## LETTER OF TRANSMITTAL

RE: Forest Lakes Bridges

COPIES	DESCRIPTION	CONTRACTOR
1	Pipe Hand Railing Shop Drawings	Structures

#### SHOP DRAWING REVIEW

PROJECT TITLE	PROJECT LOCATION
FOREST LAKES BRIDGES	MONUMENT, CO
STRUCTURE:	
PIPE RAILING	
SHEET NO.	
B18

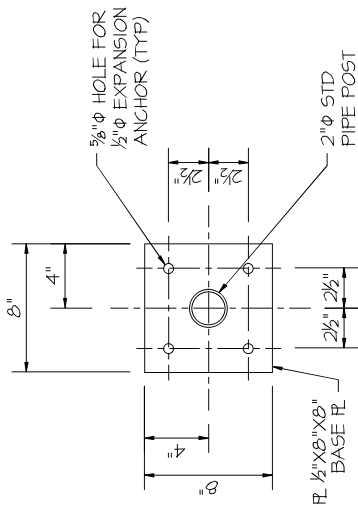
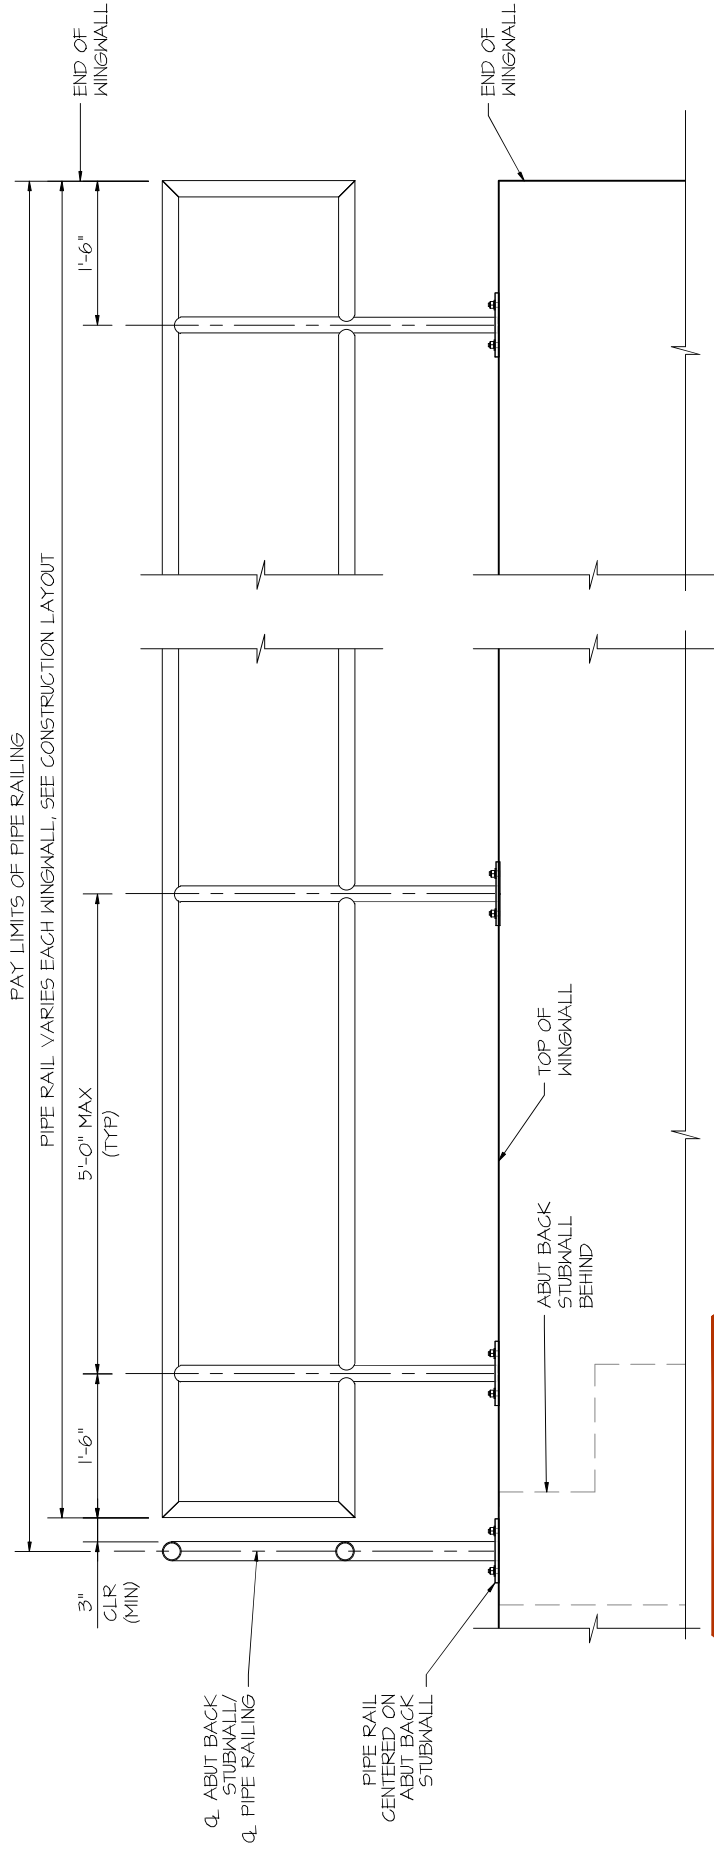
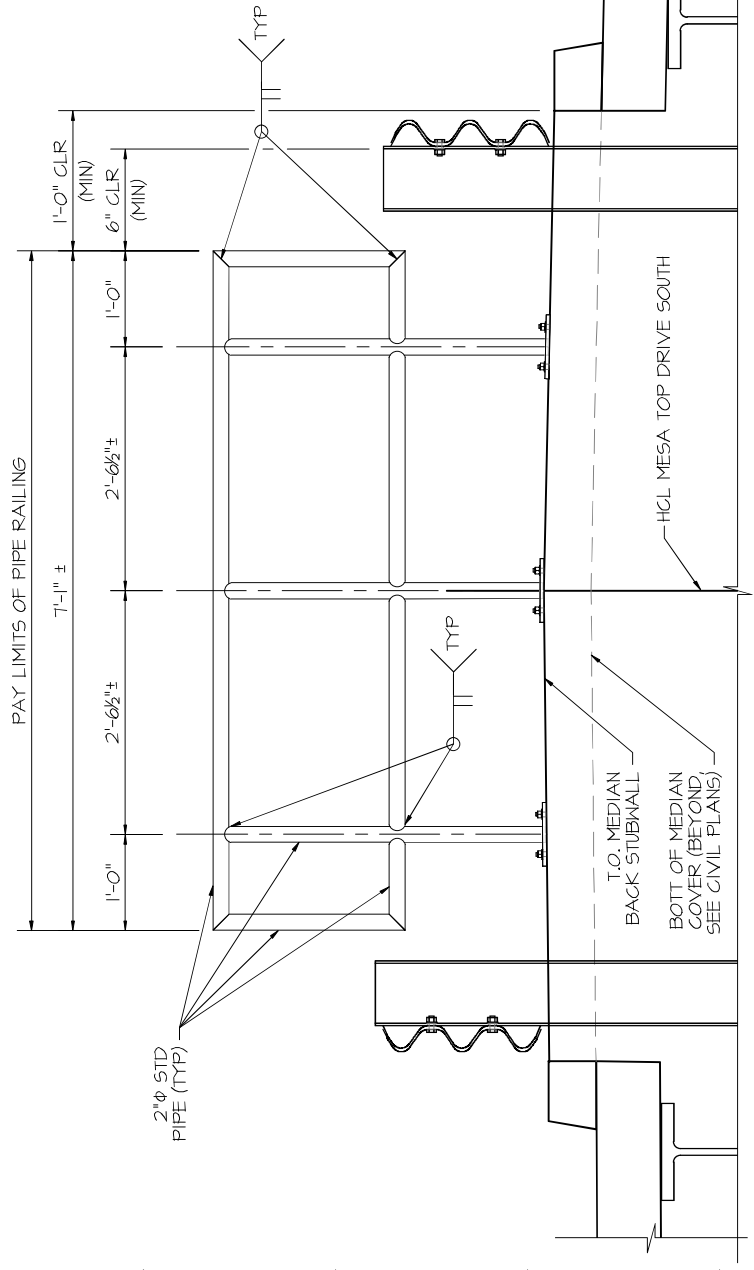
The top of the wingwalls and the medians are not level  
and the horizontal rails need to reflect the slope of the  
top of walls. Manufacturer to update horizontal rail  
angles to the vertical posts.

update angles to  
reflect the top of  
median cross  
slopes
